STATE OF WASHINGTON  
DEPARTMENT OF ECOLOGY  
1250 W Alder St • Union Gap, WA 98903-0009 • (509) 575-2490

May 18, 2017

Re: PD-16-00001 and LP-17-00004

Thank you for the opportunity to comment during the optional determination of nonsignificance process for the rezone of 4.47 ac parcel to a Planned Unit Development and divide the 4.47 acres into 34 lots. This project is proposed by MDJ Contractors, LLC. We have reviewed the documents and have the following comments.

N 54°53'30" E
19.52'
SW CORNER
N 1/2 SW 1/4
PER BK 30
OF SURVEYS,
PG 12

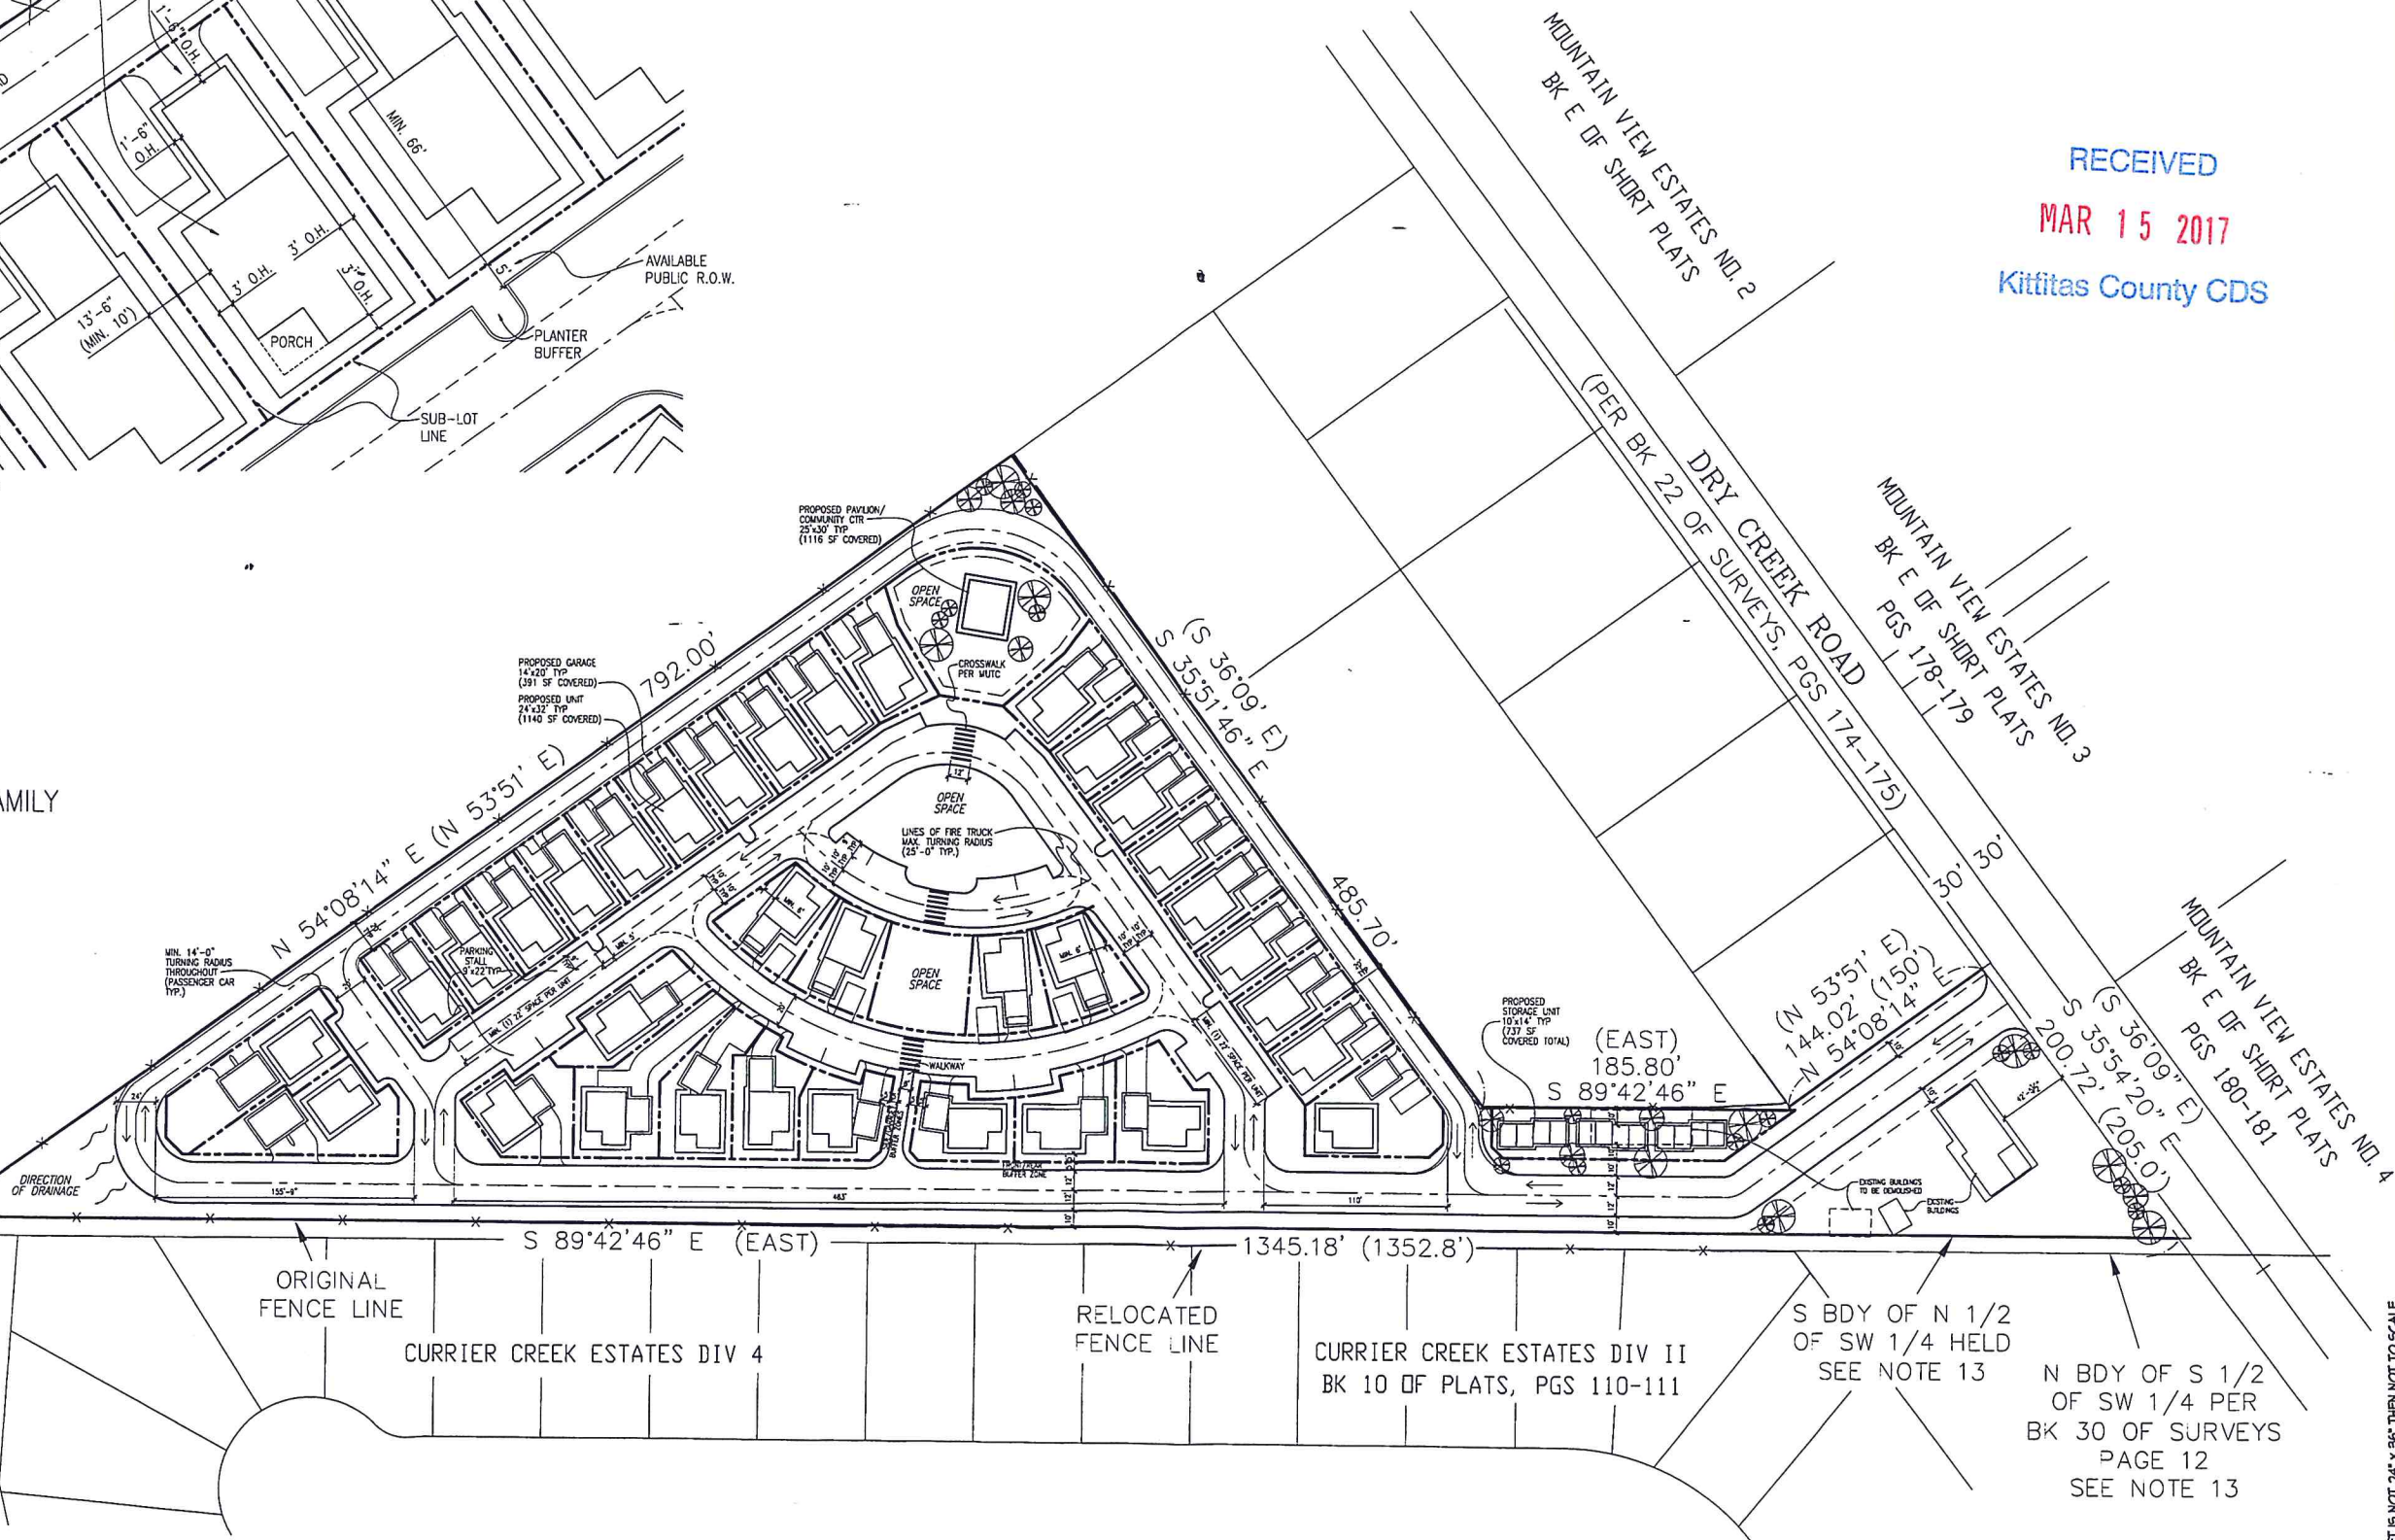
National wetland inventory maps provided at the County website show that this subdivision area is almost 100 percent wetland, but no other mention of the issue is made anywhere else in the other County documents. Was a wetland delineation completed for the site? A wetland delineation should be prepared for the site and available for public review and comment as part of the SEPA process.

Wetlands provide important flood attenuation and water quality treatment and any wetland areas on or adjacent to the site should be protected under applicable local, state and county wetland regulations. Since the project area is subject to natural flooding patterns (see aerial photo below provided to Ecology by WA Dept. of Fish and Wildlife) and because of the project area's proximity to Currier Creek, any wetlands that are found to be present on site would be subject to GMA regulations, and should be protected or mitigated in accordance with Best Available Science.

Adequate stormwater and flood retention capability should be set aside on site. This is needed in order to protect adjacent wetlands and the water quality of Currier Creek and other downstream waters.
